Ribble Valley Borough Council
Housing & Development Control

Application no: **3/2023/0384**

Address: **Honfleur 3 Grindleton View Chatburn BB7 4BE**

Proposal: **Proposed new 4 bedroom dwelling and creation of new access on land to the side of 3 Grindleton View.**

Scale: 1:100 @ A1 **Sheet:** 004 **Revision:** C

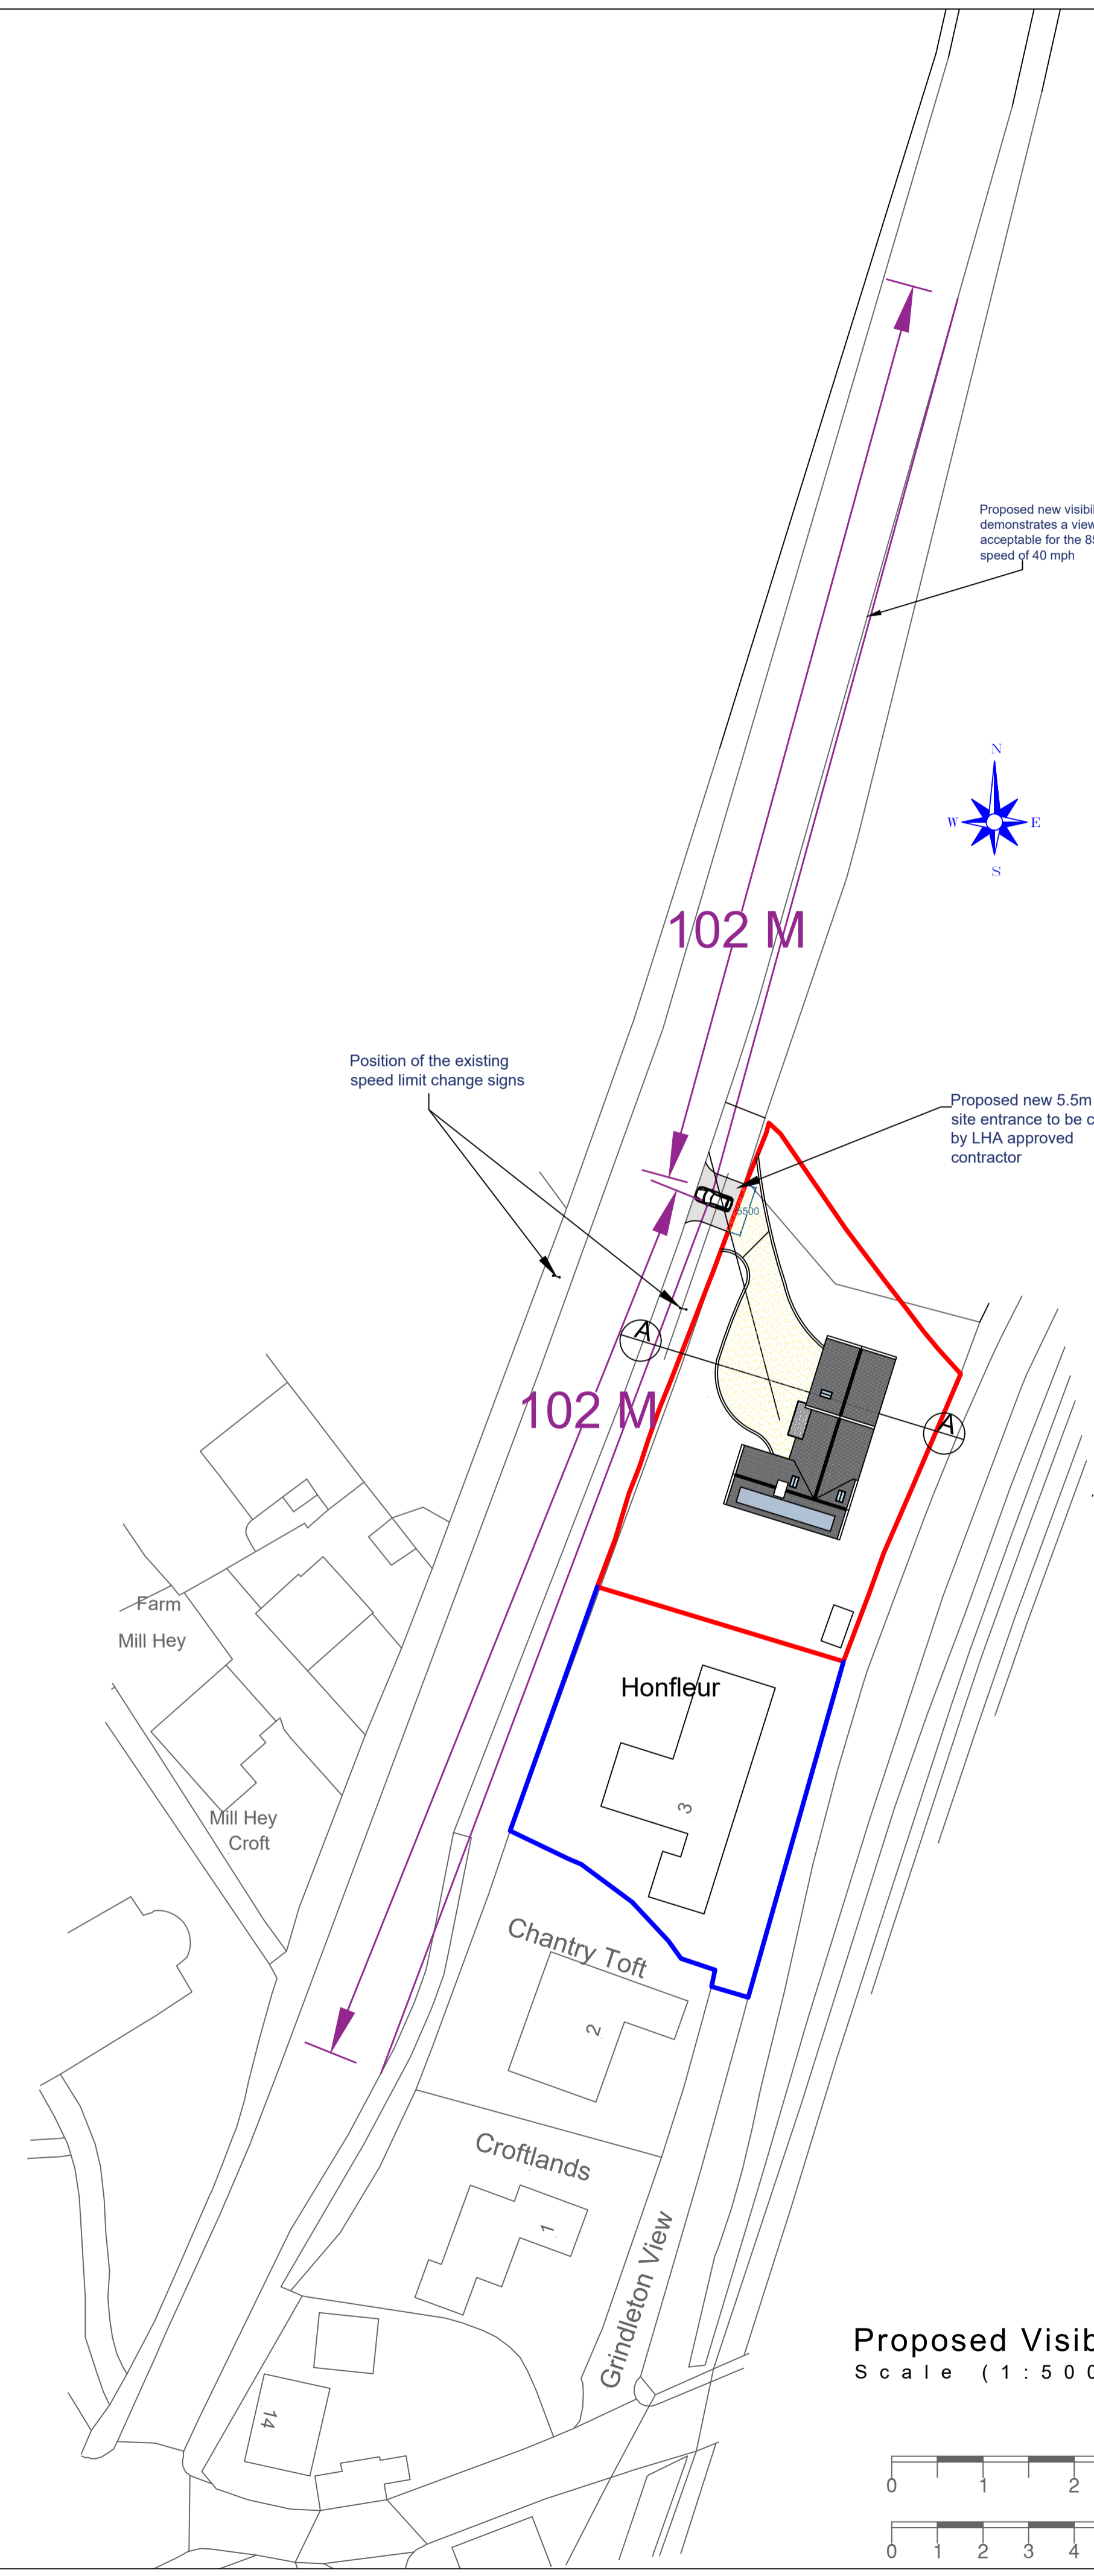
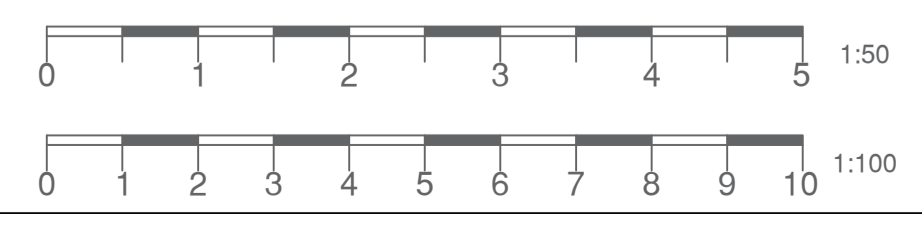
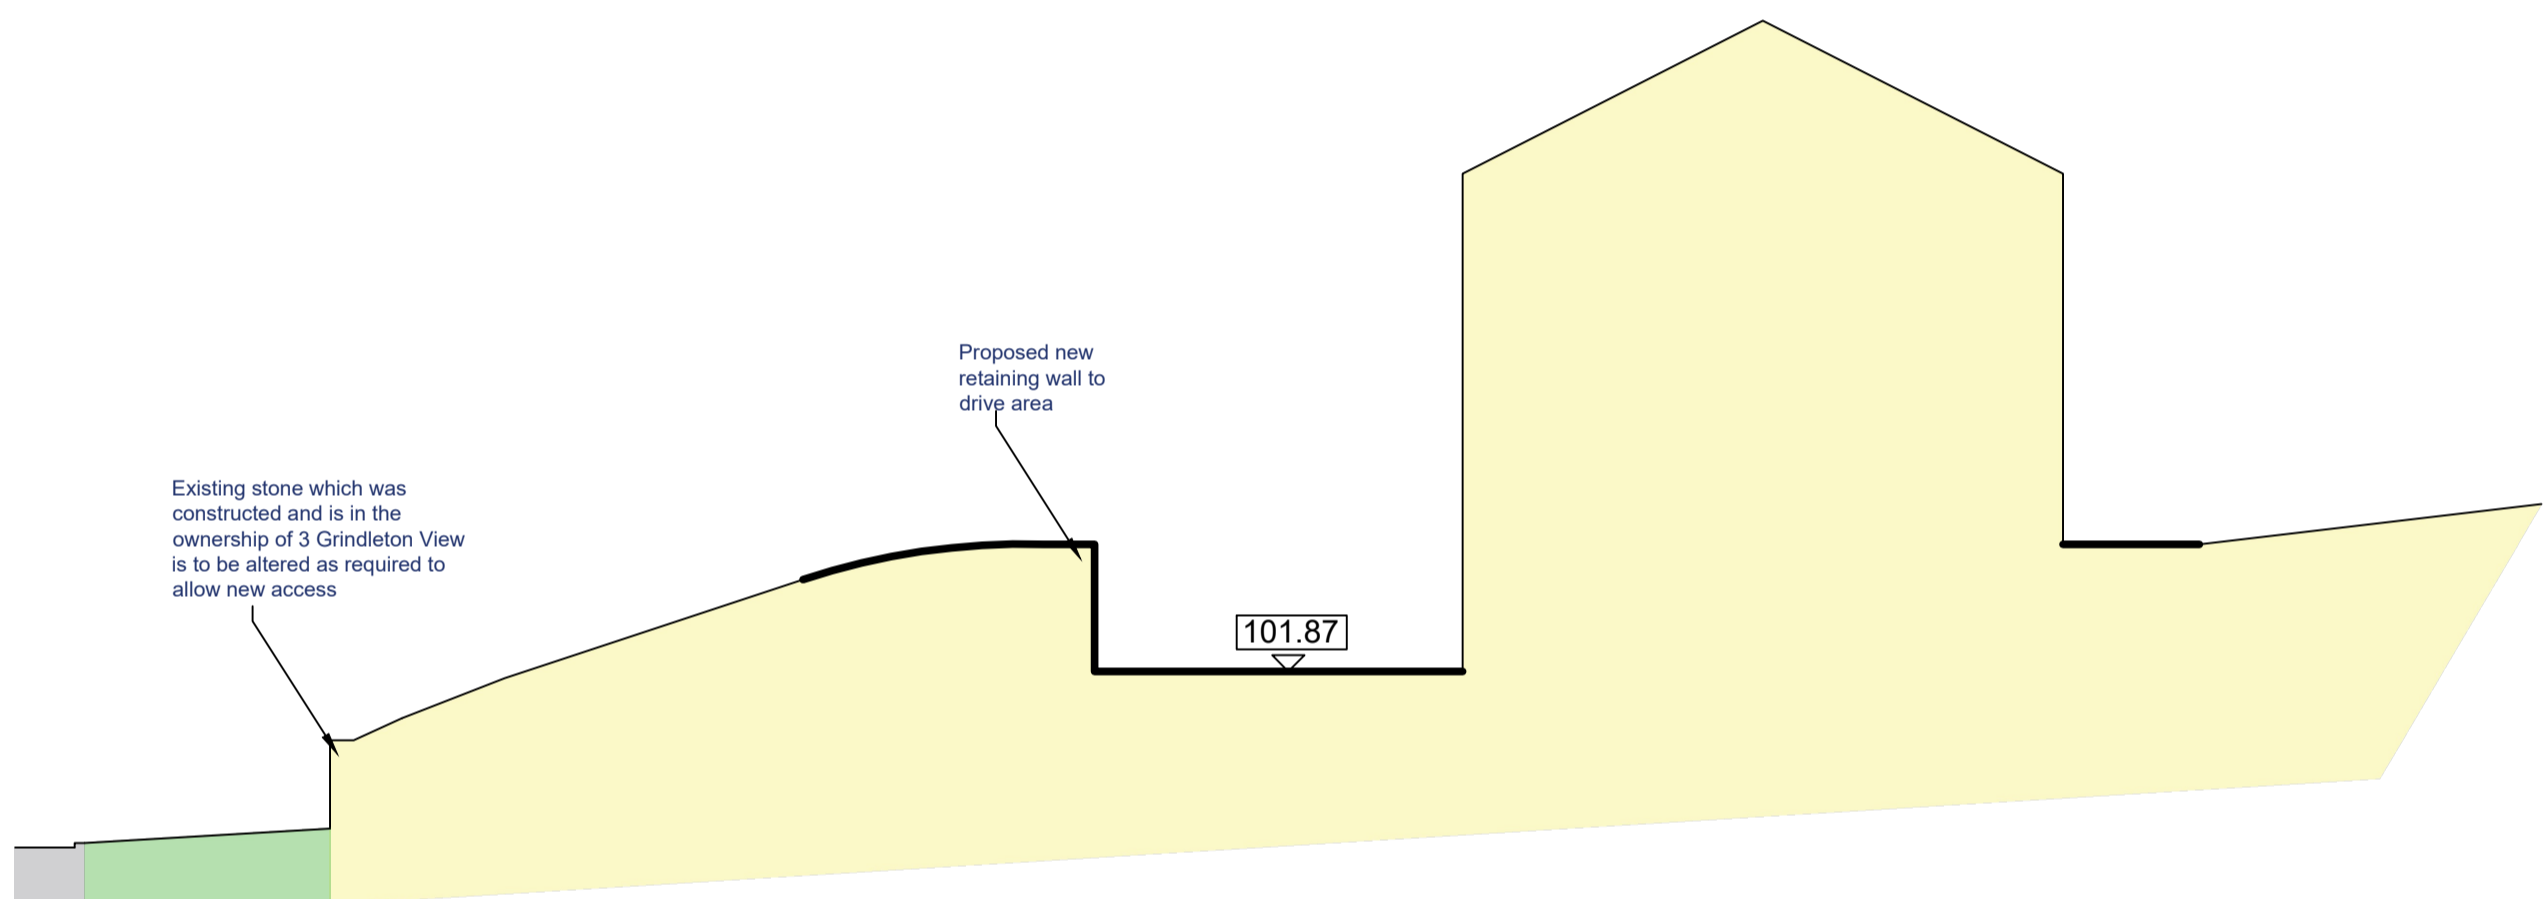
The LHA are aware that the Agent has provided on the drawing visibility splays of 2.4m x 160m to the north and 2.4m x 155m to the south. However, this does not comply with the LHAs visibility splay guidance for a 60mph speed limit, with the LHA requiring minimum splays of 2.4m x 214m in both directions. Therefore, even if the site wasn't in between two speed limits, a traffic survey is required.

The LHA have reviewed Holden drawing number 004 and are aware that a partial footway is provided which will connect to the existing southbound bus stop and will provide a link to Chatburn village centre. However, the new footway should start at the site access and then connect to the existing footway along Sawley Road. This should be shown on a revised plan and the footway should be a minimum of 2m wide.

As documented on Holden drawing number 004, the gradient at the proposed access will be approximately 1 in 11.43. This is acceptable but the LHA require site section drawings to be submitted to ensure this is consistent from the adopted highway into the site. The gradient should not exceed 1 in 10.

Date: 09/05/2023	Drawn by: JHolden
Scale: 1:100 @ A1	Ref: 003
Client: Mr & Mrs Bradley	Revision: B

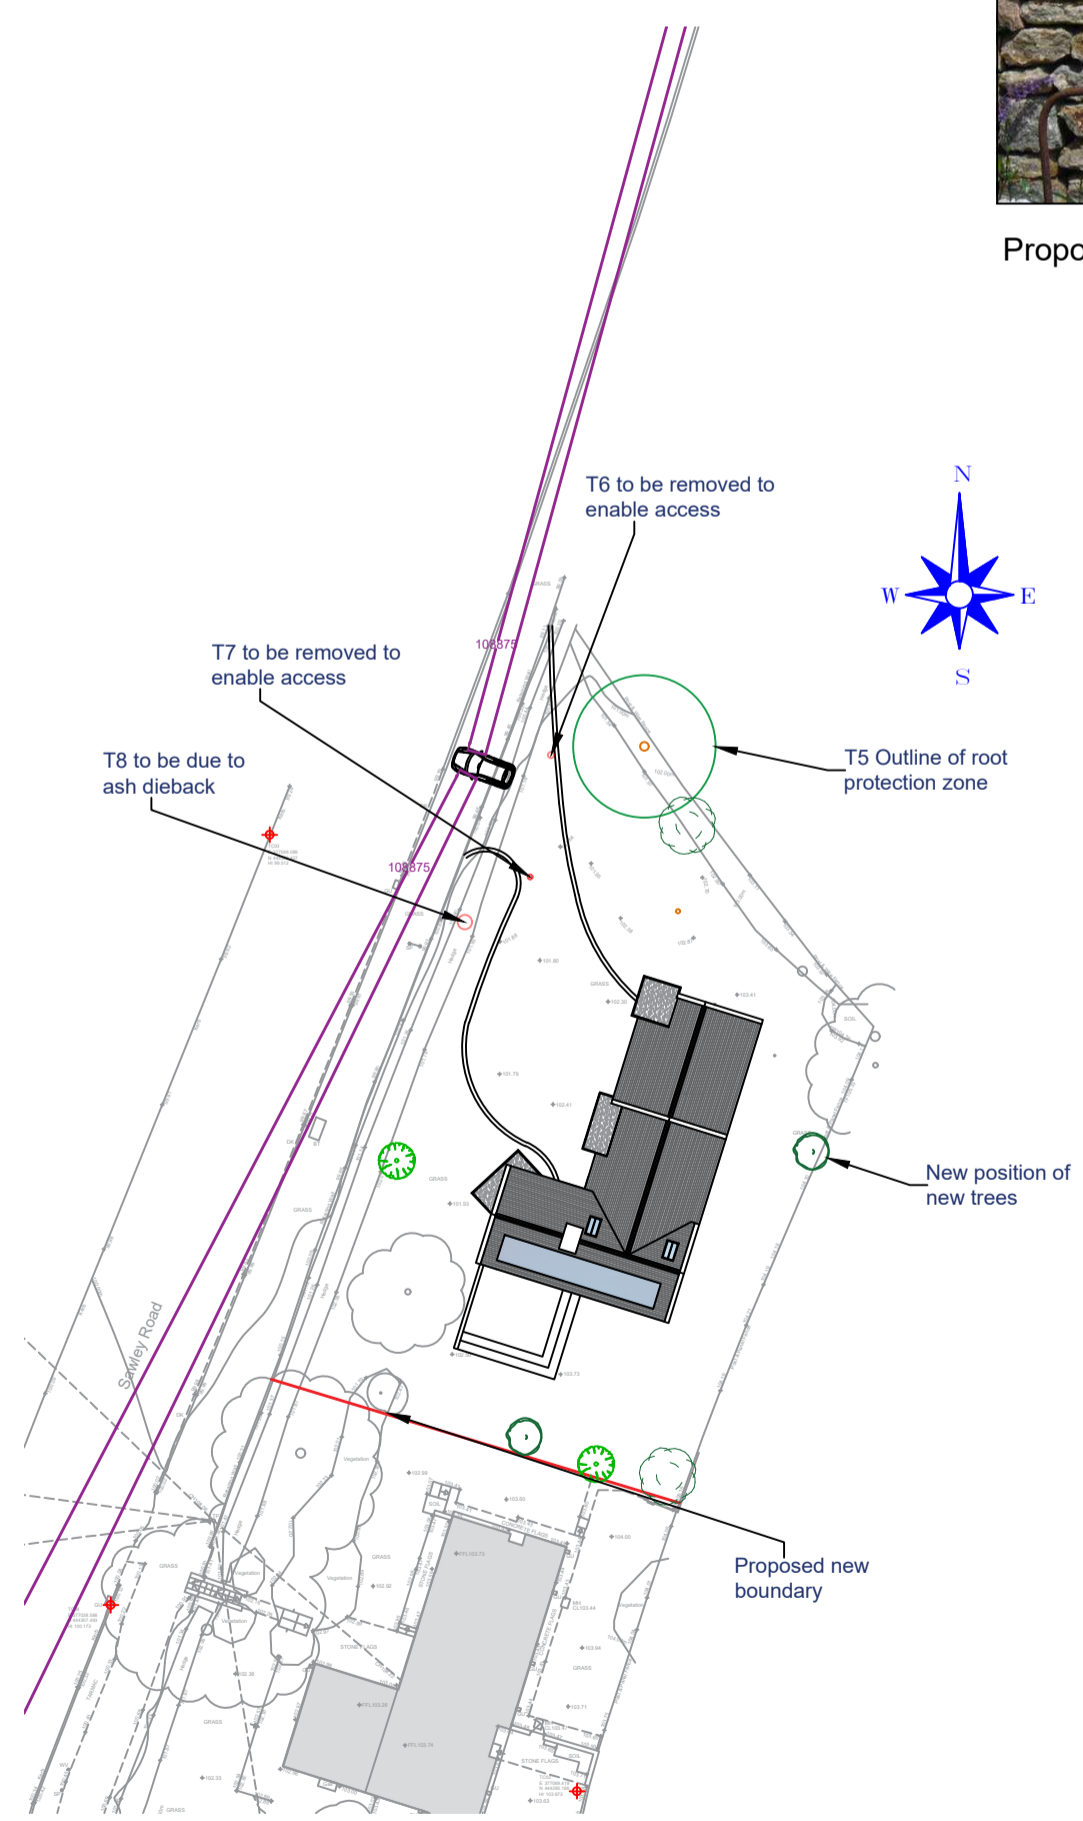
The LHA have reviewed Holden drawing number 003 Rev B titled "Proposed Plan" and are aware that the parking arrangements complies with the LHAs parking guidance as defined in the Joint Lancashire Structure Plan.
